Application No: FG/101/25/PL
Site Address: 4 South Drive Ferring BN12 5QS
Description of works: Erection of replacement dwelling together with reprofiling of the site and installation of new boundary to front of site. This application is in CIL Zone 4 and is CIL Liable as a new dwelling.

Thank you for your internet representation made on 2nd September 2025 which has been recorded as an objection with the comments as follows:

RE: 4 South Drive, Ferring
Planning Ref FG/101/25/HH

PROPOSED REAR AND SIDE
ELEVATIONS

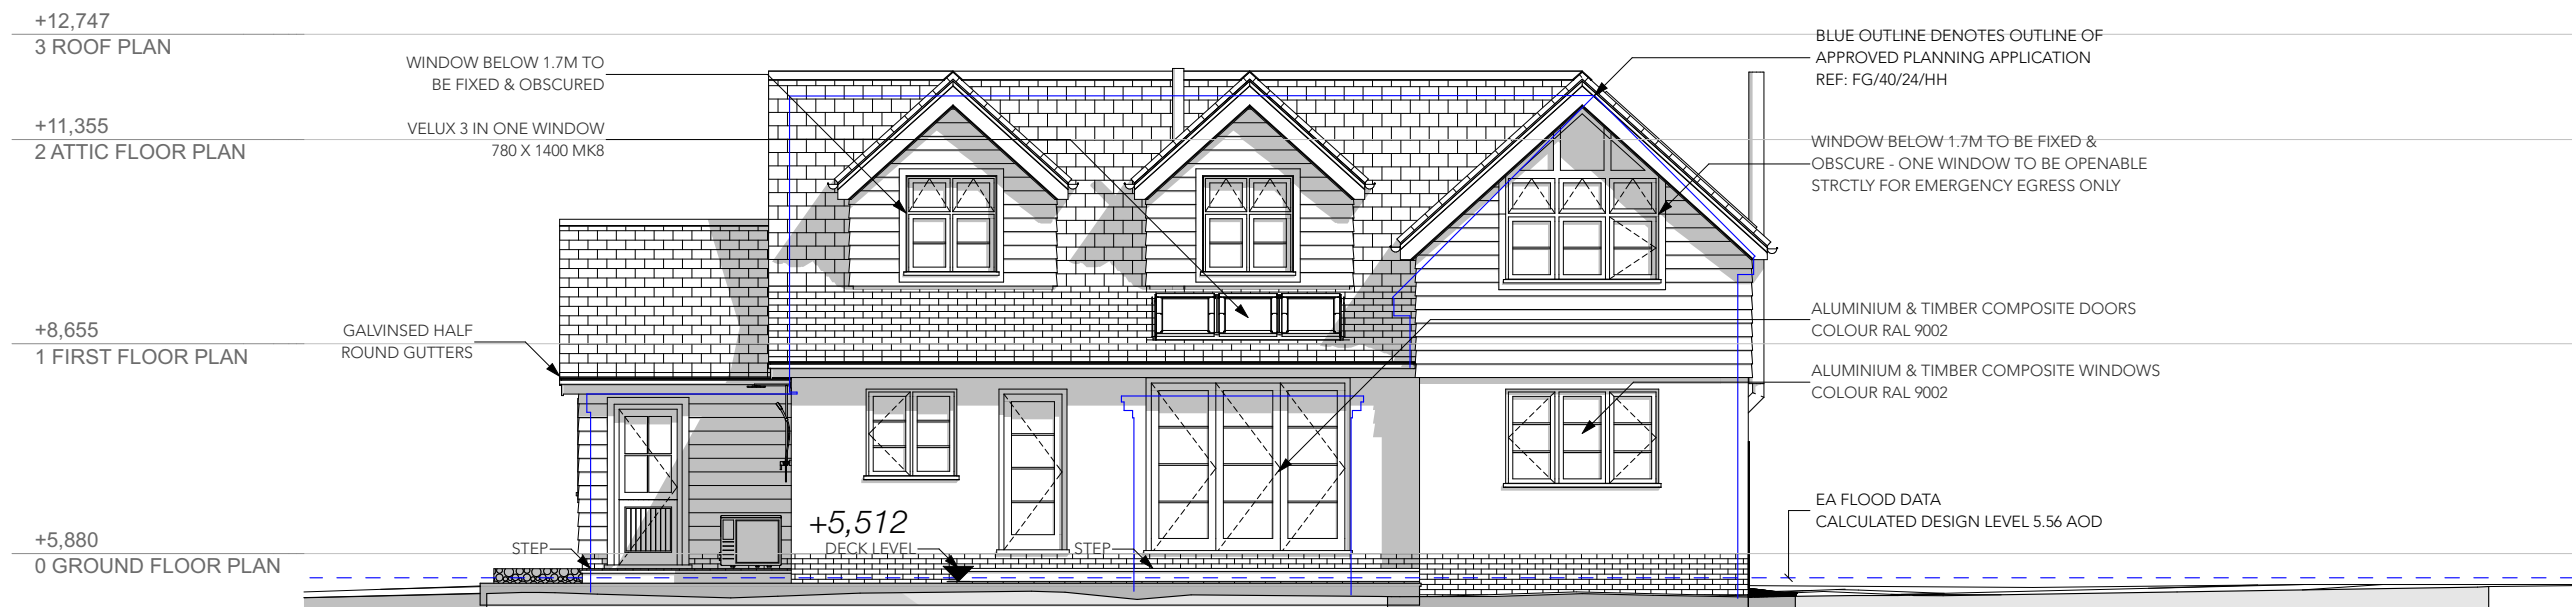
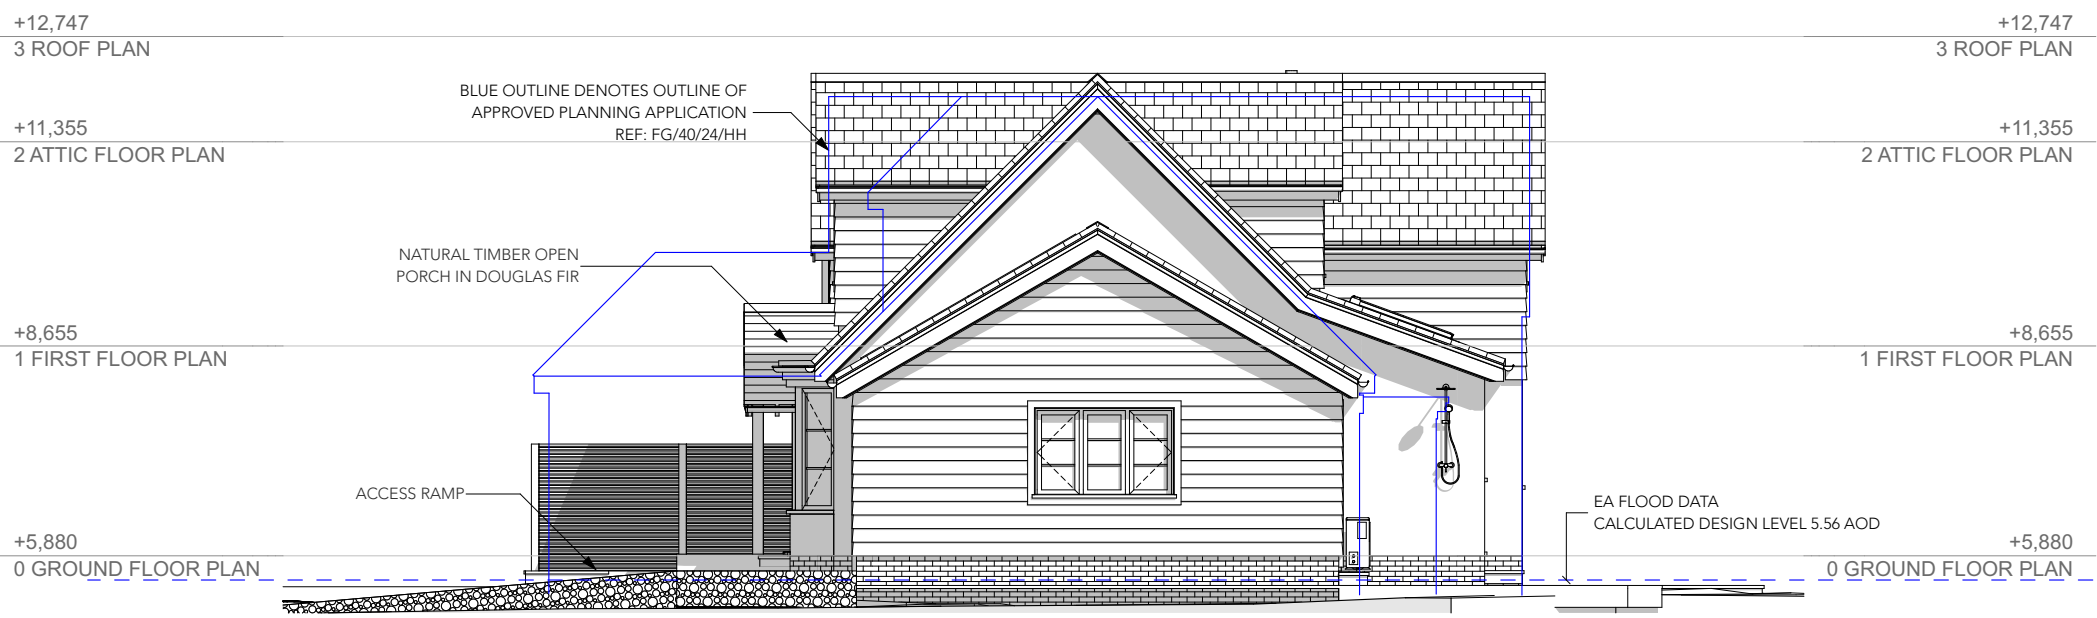
The proposed development would have an overbearing effect on our single storey bungalow due to the bulk of the new building. There would be a tall 1 storey building within 3 m of our boundary resulting in loss of light. There would be windows at first floor level on the North elevation which would overlook our garden resulting in loss of privacy.

- All first-floor windows on the North and East elevations to be non-opening and fitted with obscured glass.
- Limits to working hours, preferably 8am to 4pm weekdays only.
